A303 Sparkford to Ilchester Dualling Scheme TR010036

8.8 Draft Statement of Common Ground with Defence Infrastructure Organisation

DRAFT STATEMENT OF COMMON GROUND

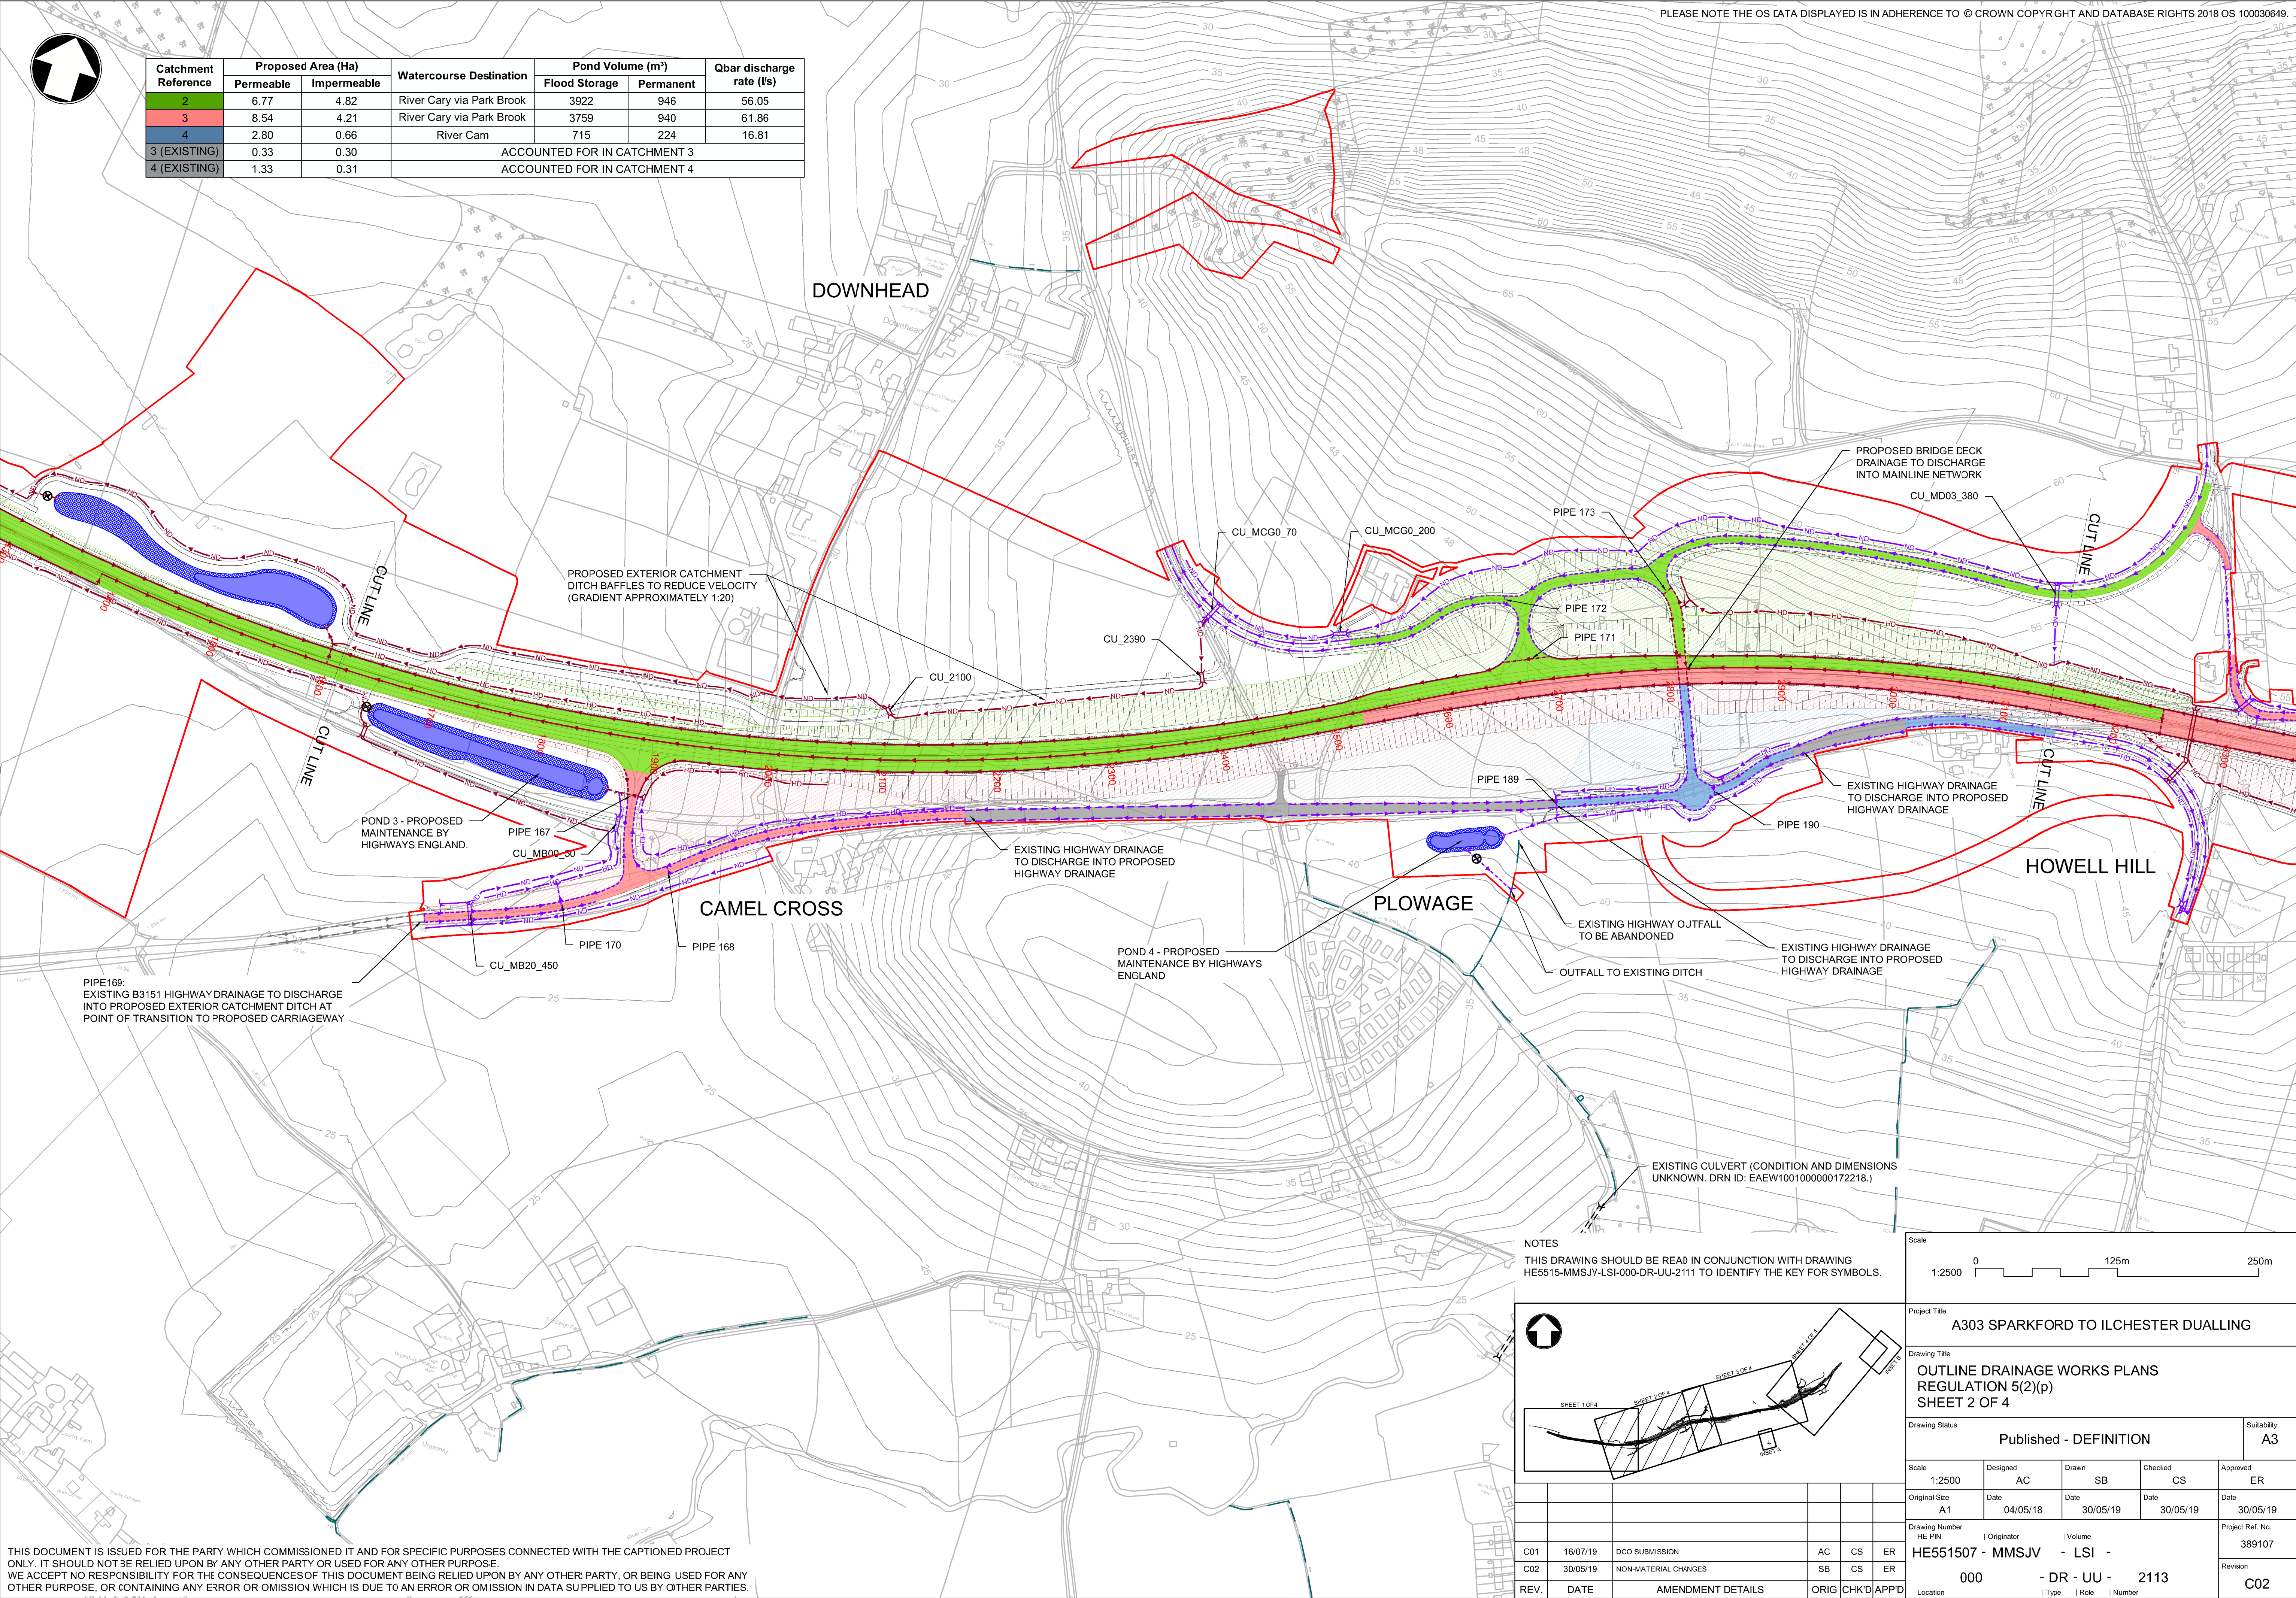
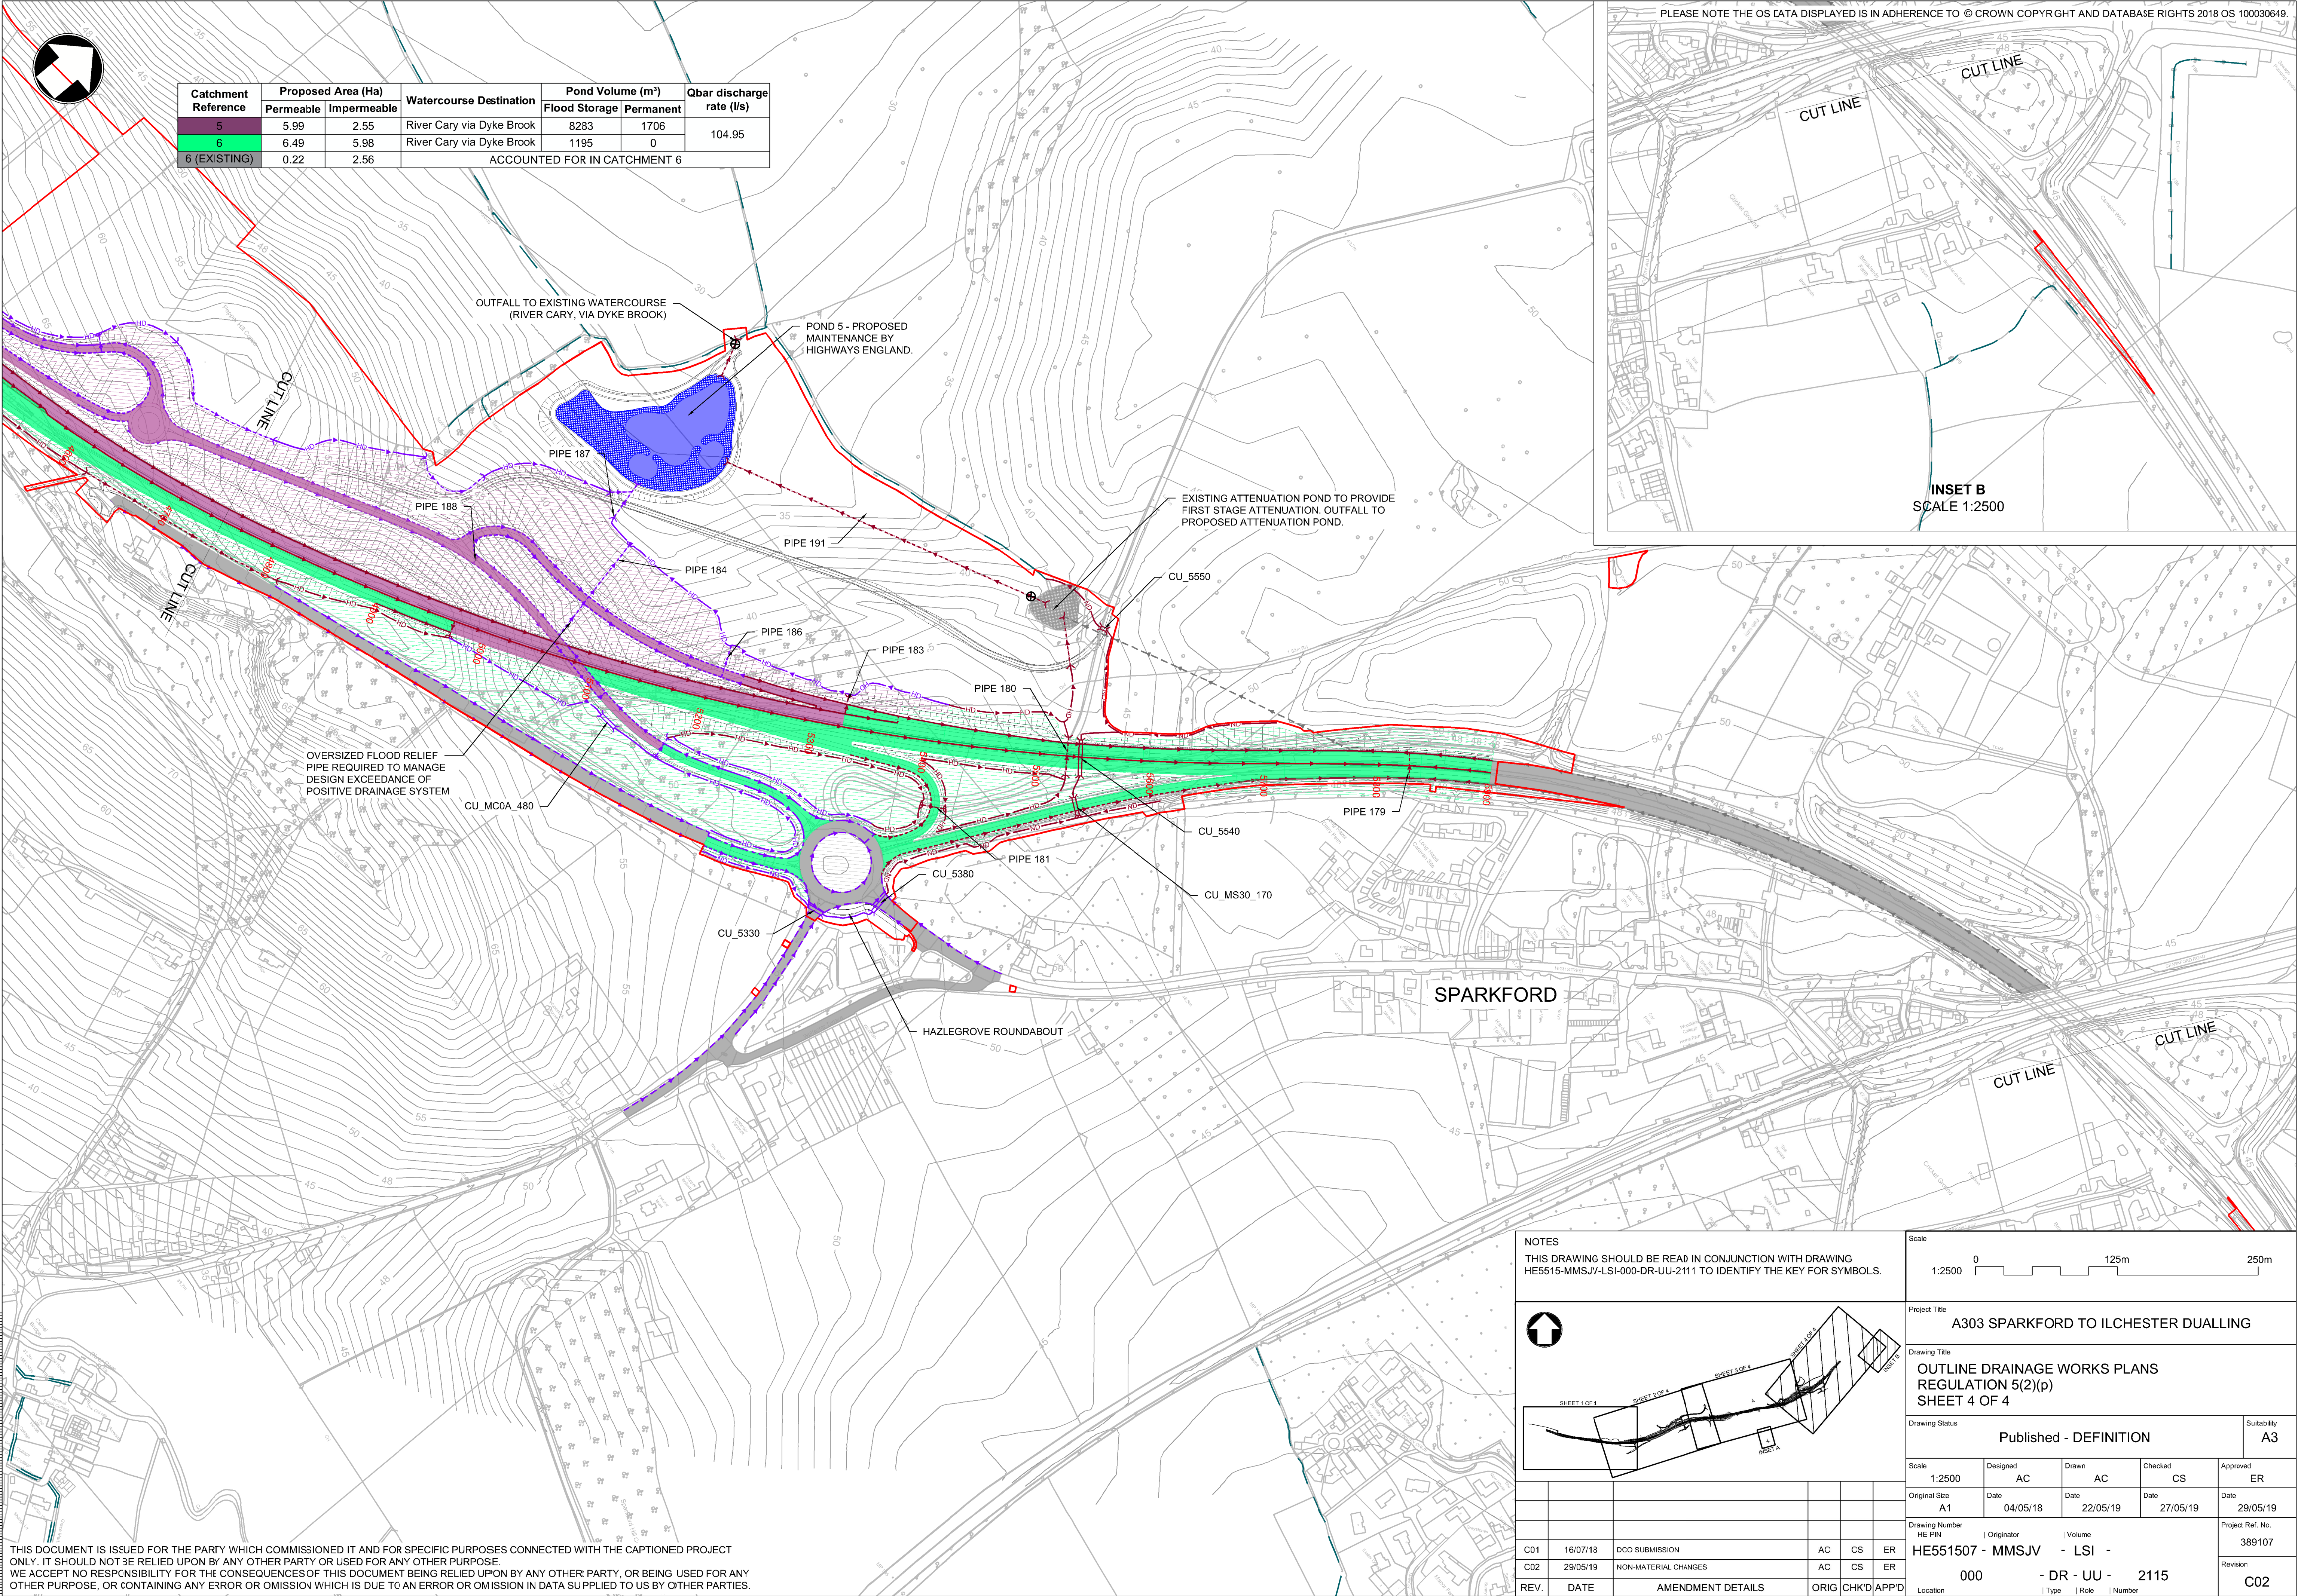
Topic	Sub-section	Defence Infrastructure comment	Highways England response	Status
General support to the scheme	General support for the scheme	The DIO supports the scheme and agrees for the need.	Acknowledged.	AGREED
Aerodrome safeguarding	Bird-strike safeguarding.	<p>The plan to build ponds to contain permanent standing water would attract birds and increase the risk for bird-strikes.</p> <p>The MOD statutory birdstrike safeguarding concerns remain extant. On meeting with HE we agreed if the ponds could not be dry i.e. only collect water during rainfall they should dry down within 72 hours following a 1 in 100 year storm event, there are alternative design principles such as densely planting the ponds with reeds in particular common reed Phragmites Australis as this provides a continuous year round barrier and does not die back in winter. The bank sides are to be as steep as possible and the reeds will need to be managed via a Bird Hazard Management Plan to ensure the reed is maintained to reduce the risk of attracting and supporting bird species deemed hazardous to aircraft safety in this area such as gulls, starlings etc. DIO understand at present detailed designs are not available and we would only be able to remove our concerns once formal pond designs are submitted for safeguarding analysis.</p>	<p>Highways England met with the MOD and DIO on 9 May 2019 to discuss the bird strike risk in relation to the proposed ponds. Highways England understands the concern raised by the DIO and believes there are a number of design options available to mitigate the risk to an acceptable level. Such options include designing the ponds to not hold water permanently; densely planting the ponds with reeds to deter birds; or designing the permanent body of water to be small so not to encourage birds – or a combination of these measures.</p> <p>In addition to the above, there will be no public access to these ponds to eliminate possible bird feeding.</p> <p>It is noted that the DIO consider the bird-strike risk still remains, however it was agreed during the meeting on 9 May 2019 that the above proposals are detailed design points and that the DIO will be consulted on the final design of the ponds during the detailed design.</p>	AGREED
